**Re: Montessori School, 3831 Midway Pl. NE,
(E-17/D042)**

RE: **Montessori School Tenant Improvements, 3831 Midway Place NE (E17-D 042)**
Revised Grading & Drainage Plan for Building Permit (PE Stamped 07-28-08)

RE: **Montessori School Tenant Improvements, 3831 Midway Place NE (E17-D 042)**
Drainage Plan for Building Permit (PE Stamped 03-28-08)

# REVISED GRADING & DRAINAGE PLAN

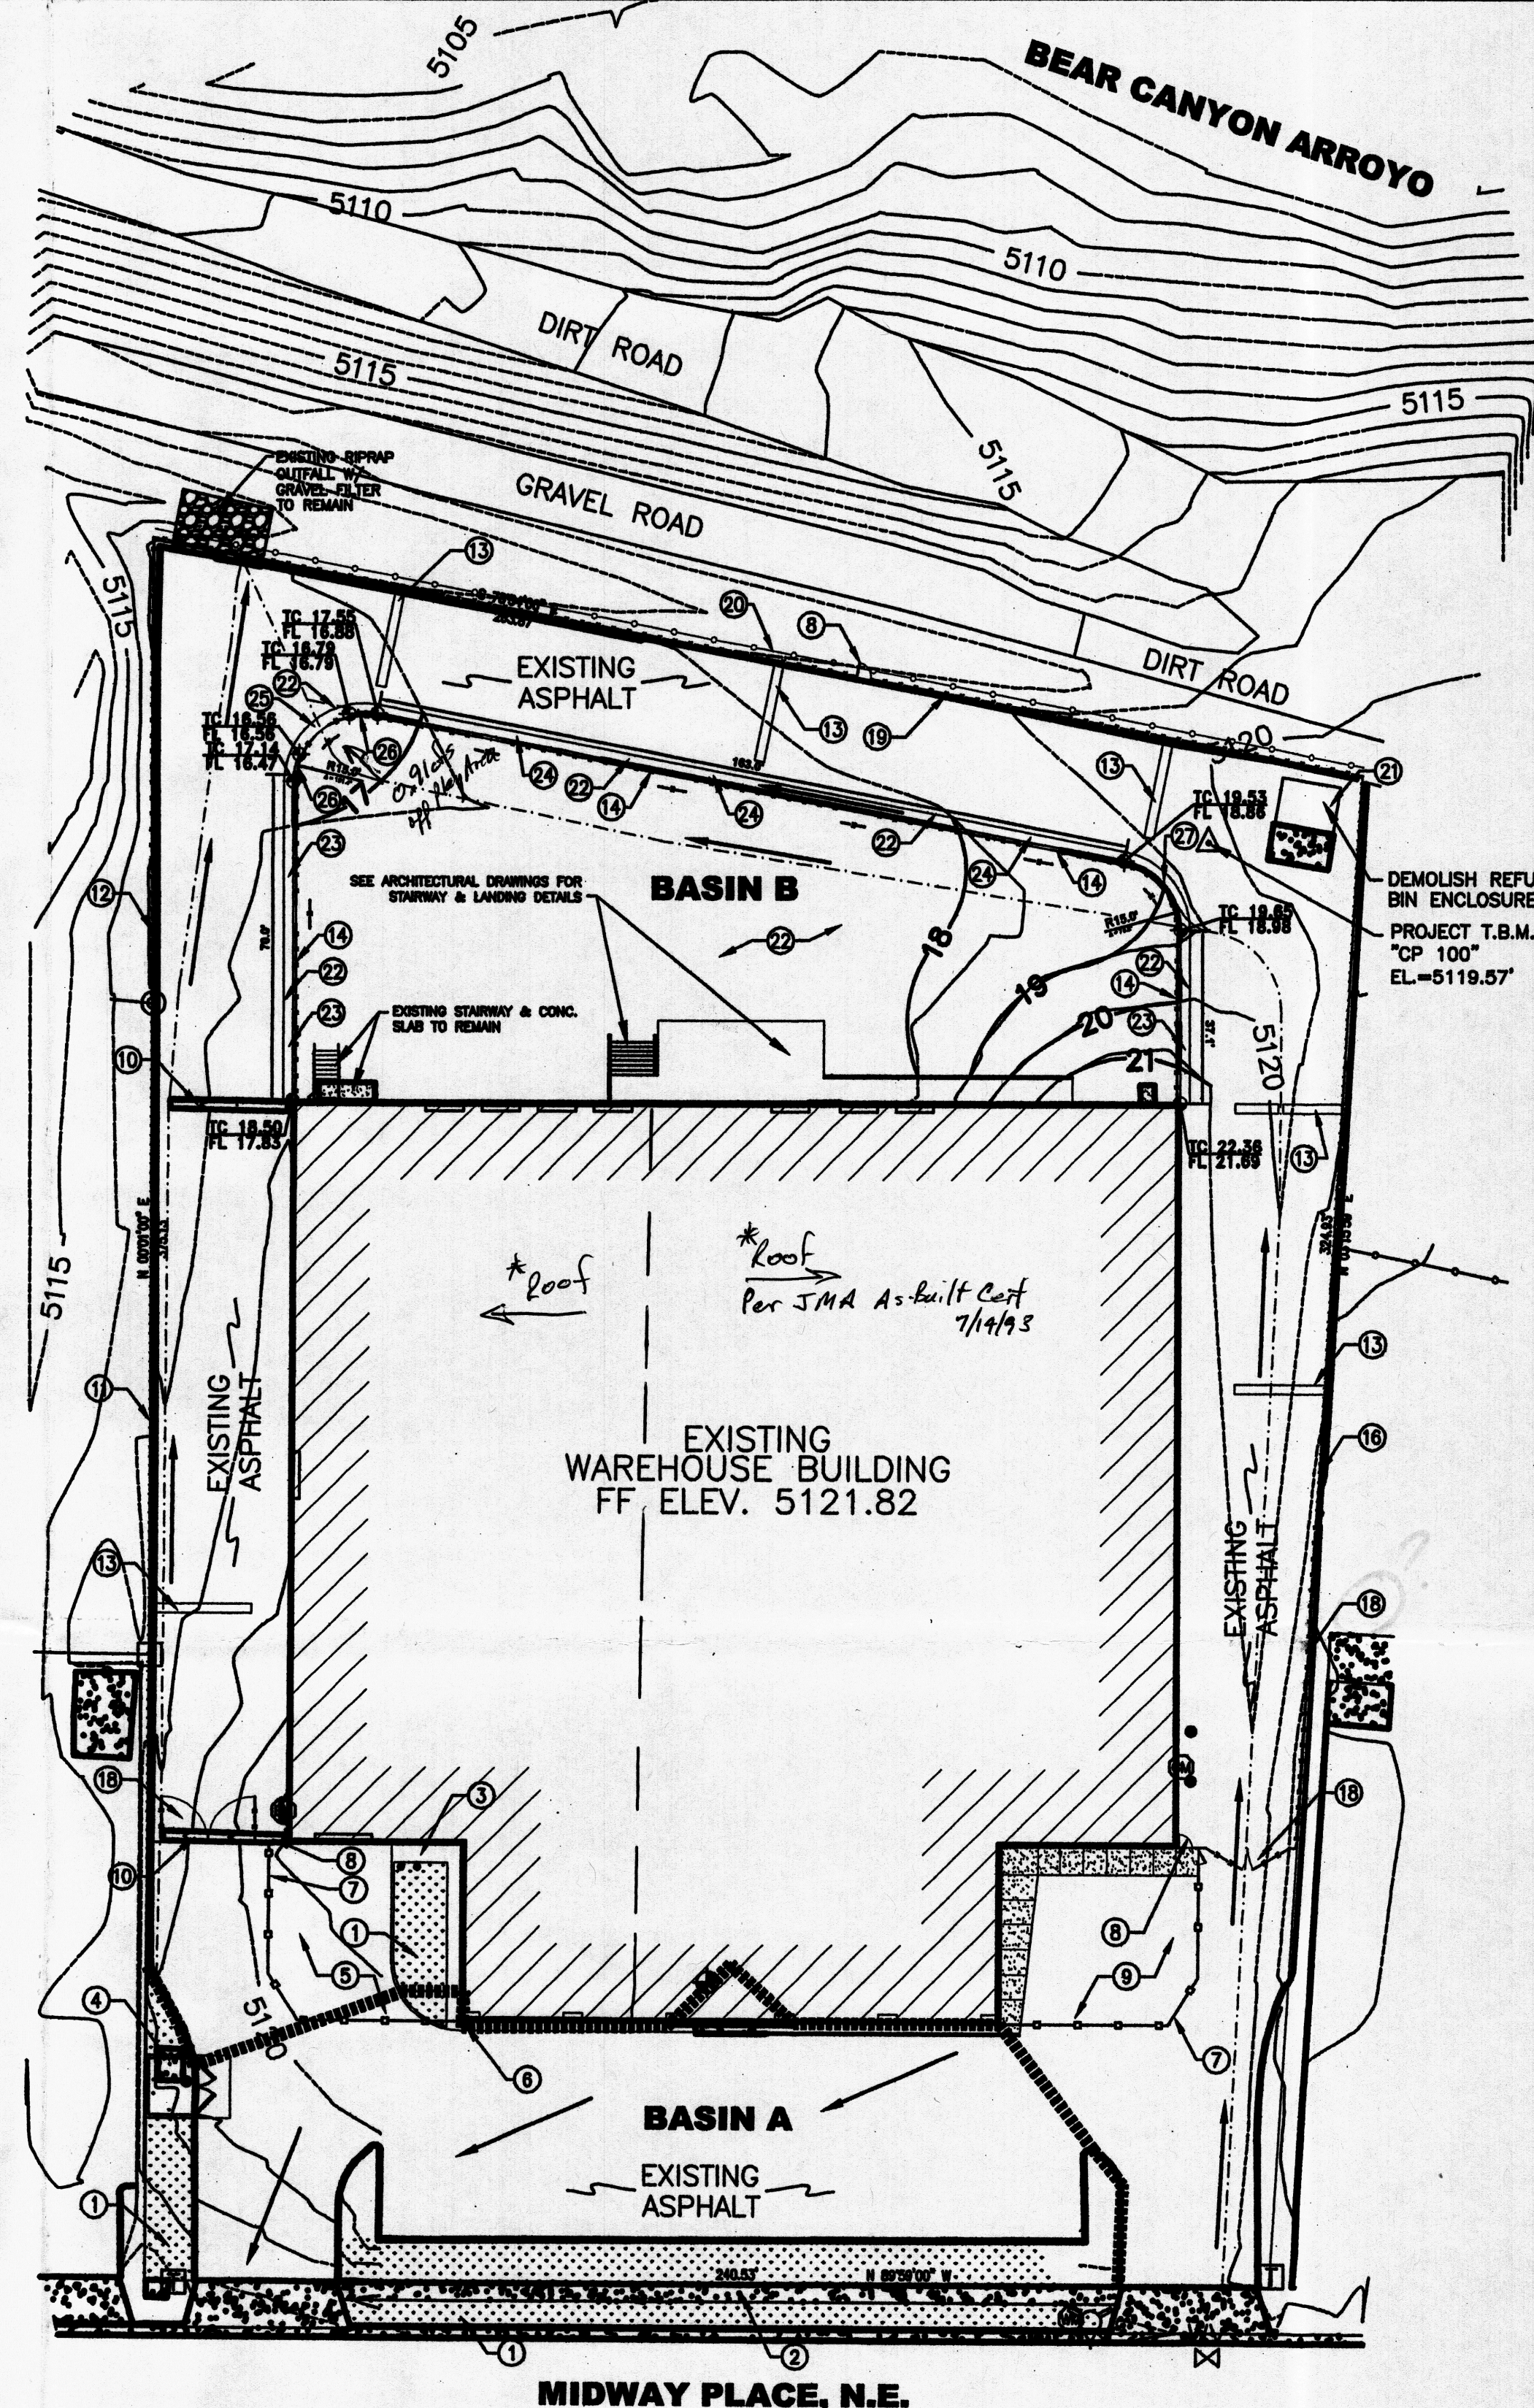
James
You may have trouble
w/ Sand washing out
NW corner of play area
at "Ribbon Curb."
Gregory R. Olson
8/4/08
